OFFICIAL NOTICE OF DECISION

CITY OF ALBUQUERQUE
PLANNING DEPARTMENT
DEVELOPMENT REVIEW BOARD

1. Project # 1002663

GREATER ALBUQUERQUE HOUSING PARTNERSHIP request(s) the above action(s) for all or a portion of Tract(s) E, NEW MEXICO CREDIT CORPORATION, (to be known as **EL PORVENIR SUBDIVISION**) zoned SU-2 special neighborhood zone, C-3, located on ARNO ST NE, between LOMAS BLVD NE and MARBLE AVE NE containing approximately 2 acre(s). [REF:03DRB-00804 (SK)] (J-14)

MONUMENT LEGEND

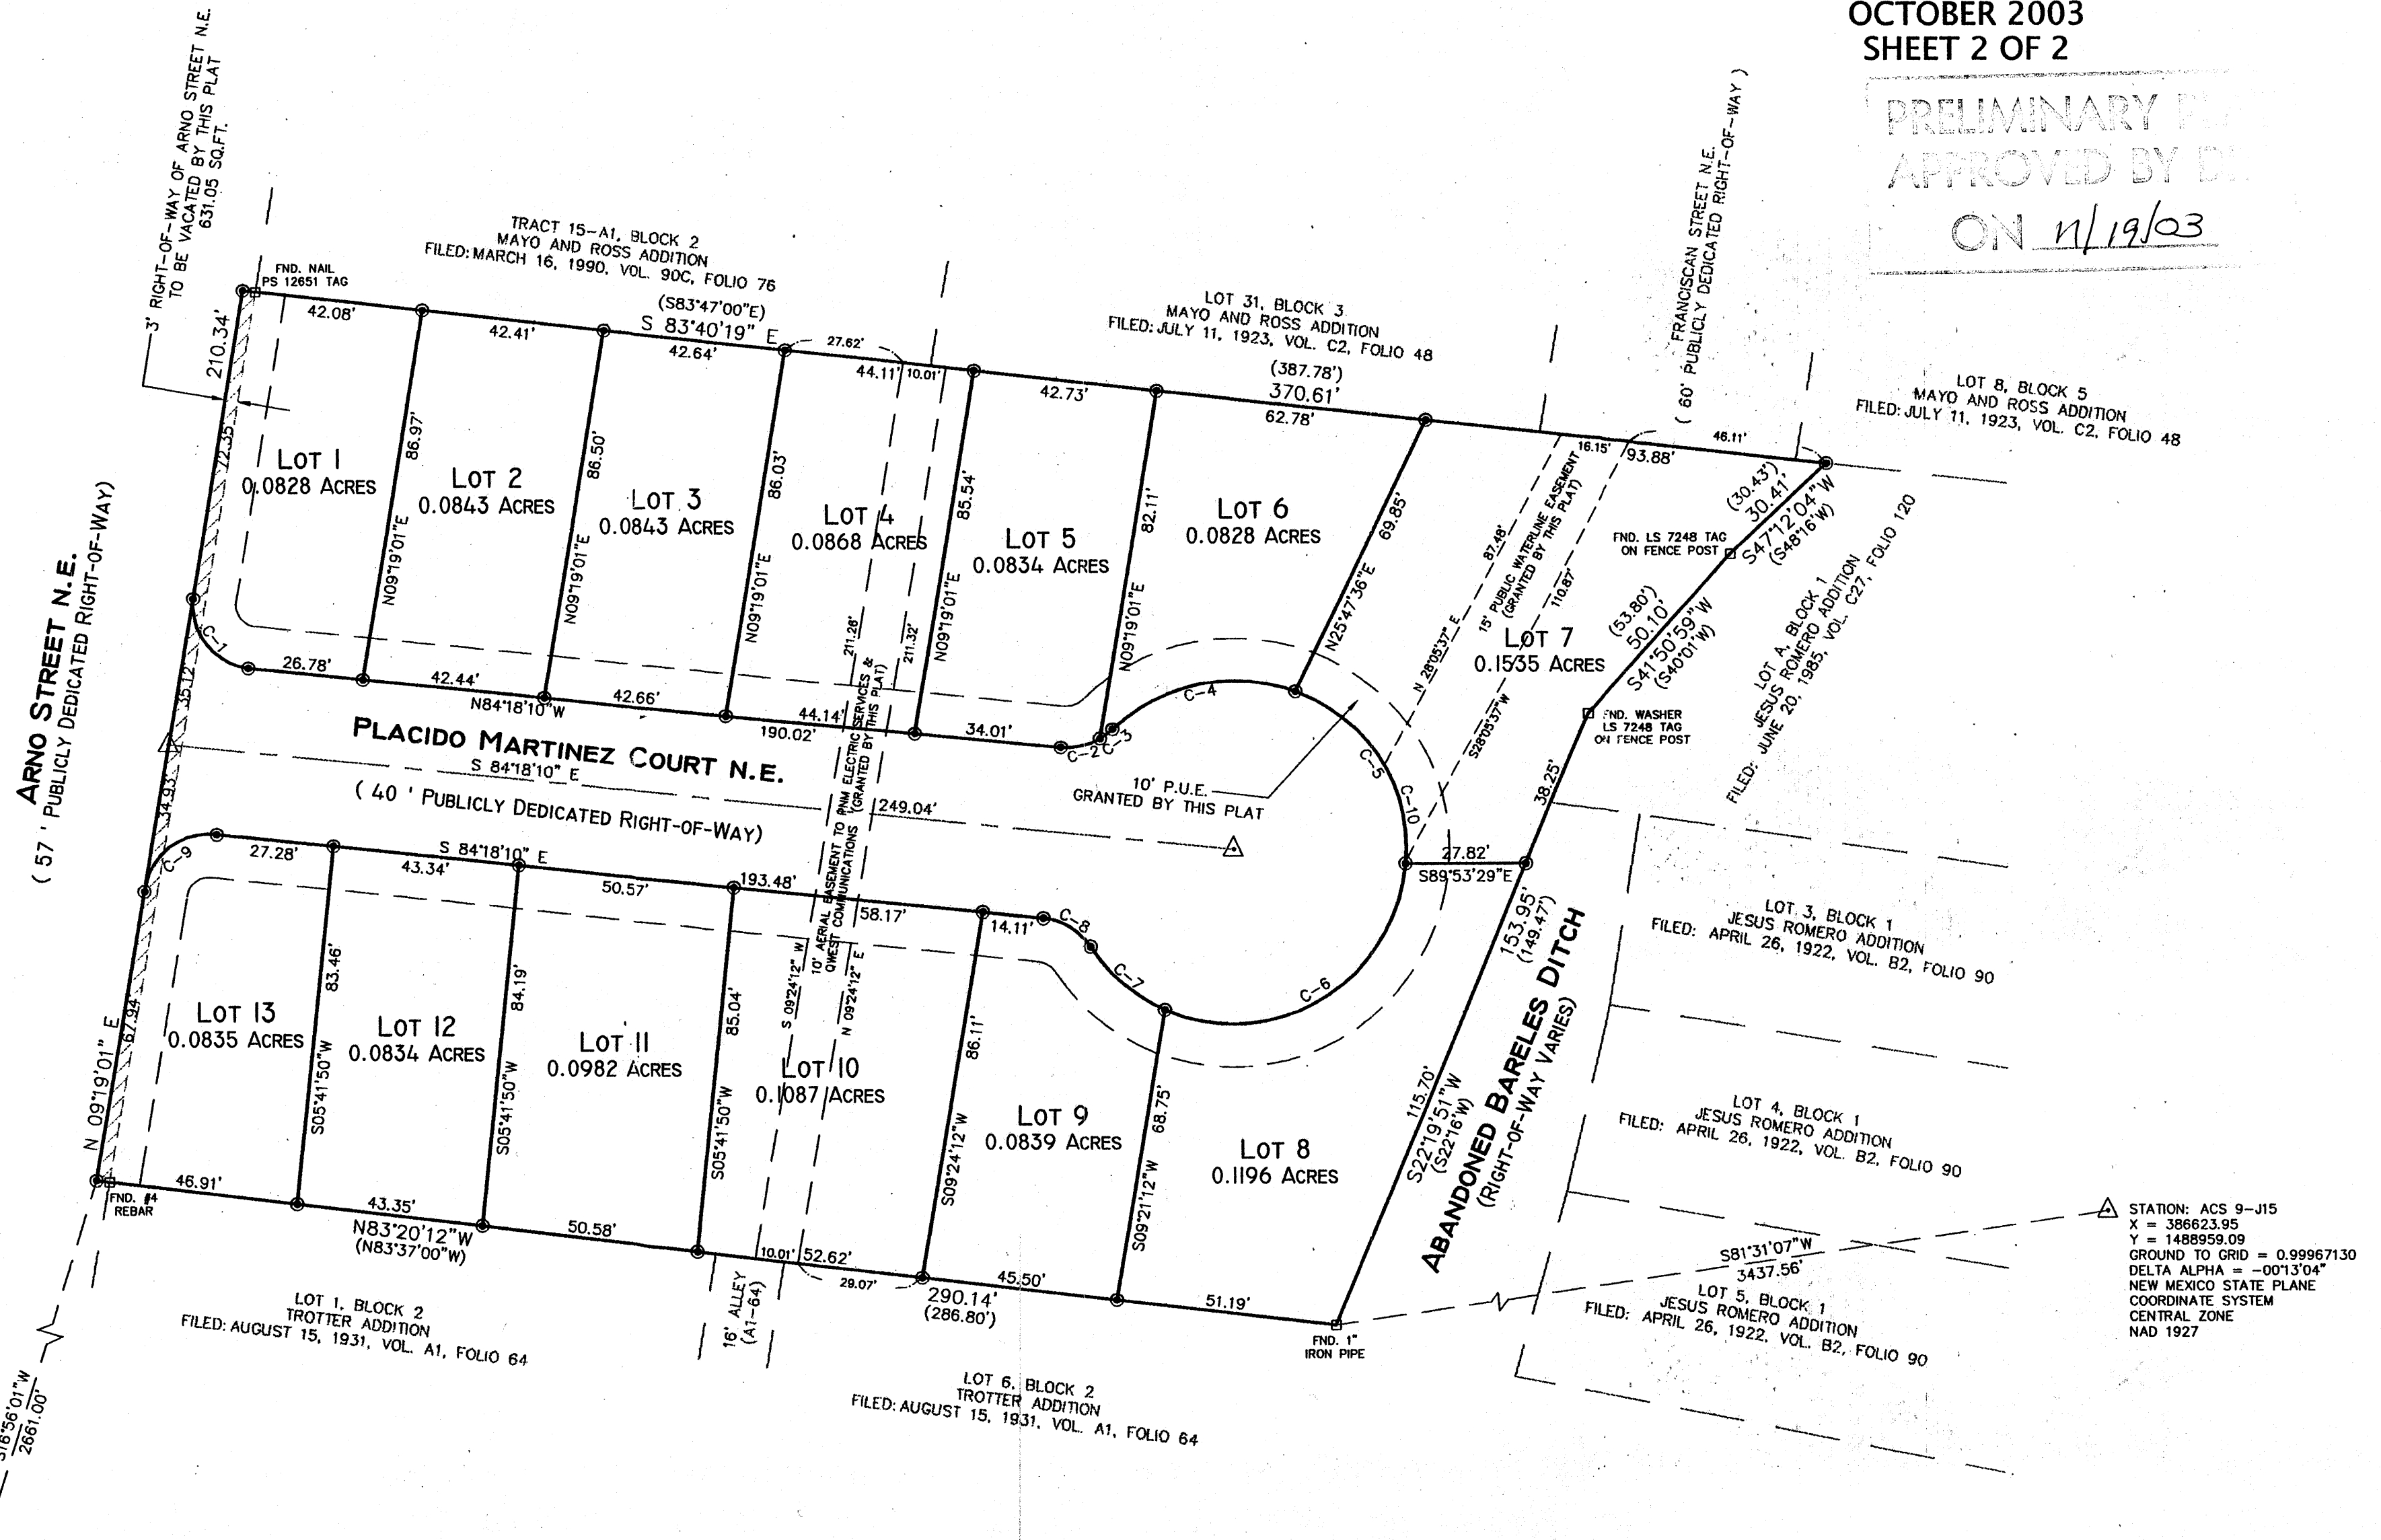
- 1) Reflect the radius as 20-feet instead of 15-feet.
